Application No: K/2/22/HH
Site Address: 43 Golden Avenue East Preston BN16 1QX
Description of works: 2 storey front and rear extensions and alterations.

OWQC44624

Council has no objection providing the case officer is satisfied that:

Proposed Front (West) Elevation

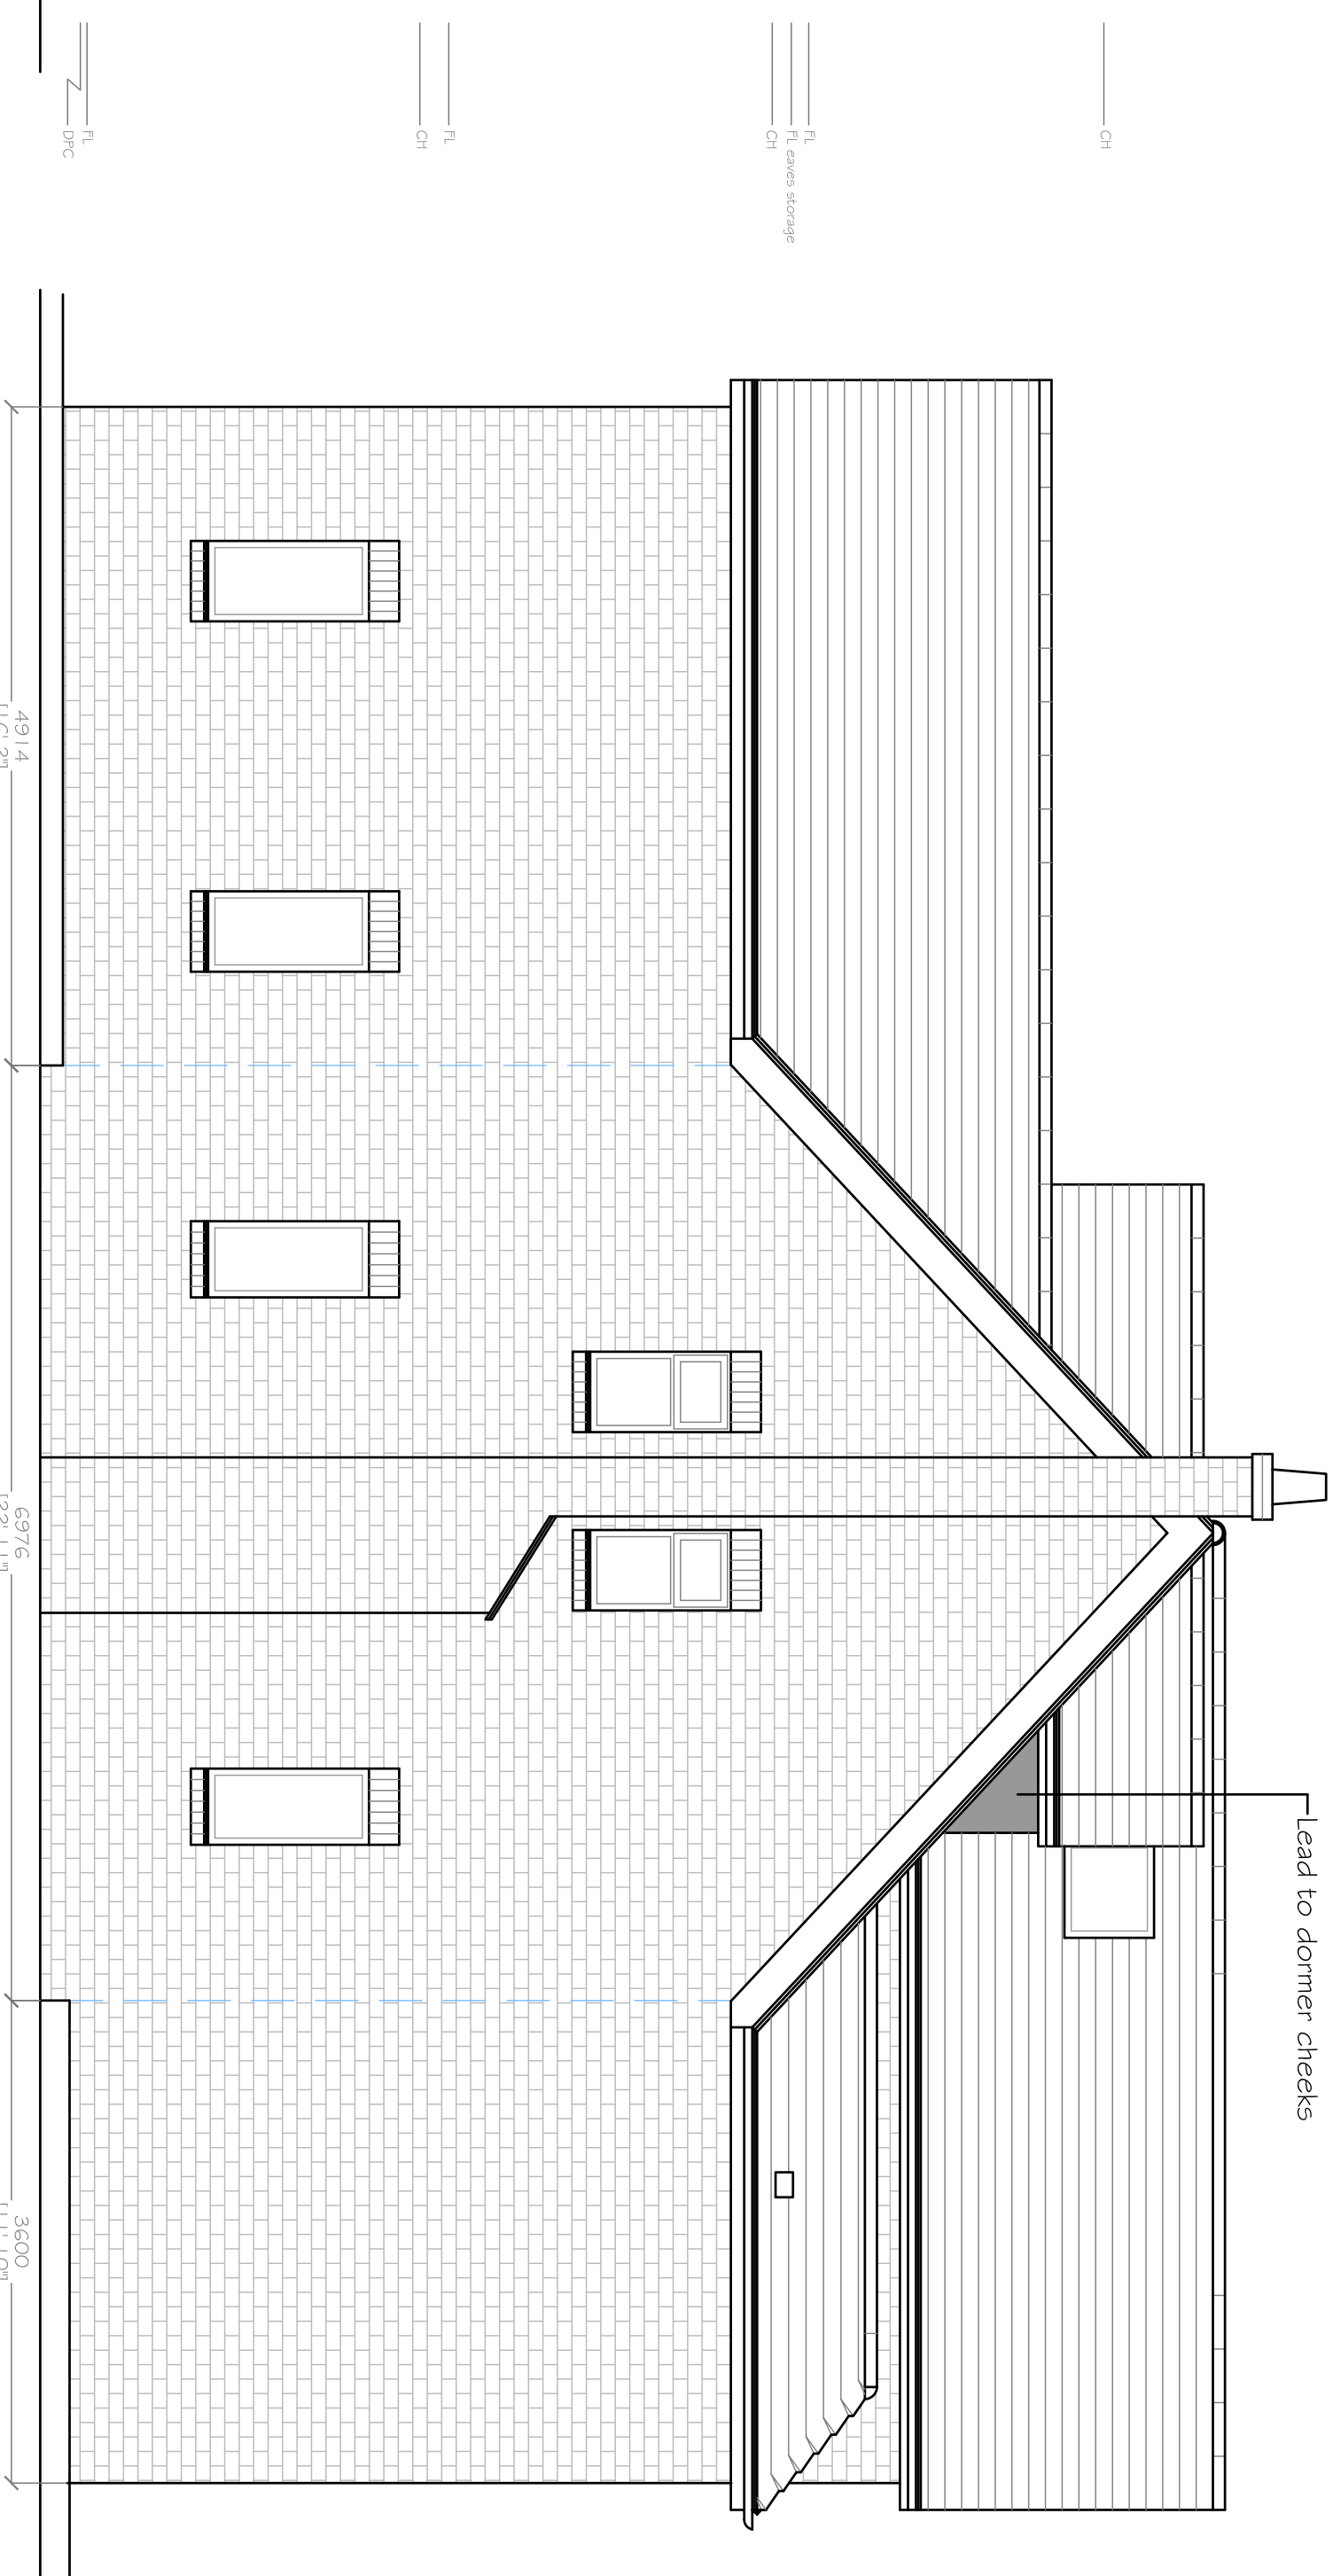
- there is appropriate on site parking for a 6 bedroom property
- windows on the side elevations have appropriate conditions as required to protect the privacy of neighbouring properties
- the new dormer windows and the new balcony at the rear on the second floor have appropriate conditions if required, to protect the privacy of neighbouring properties
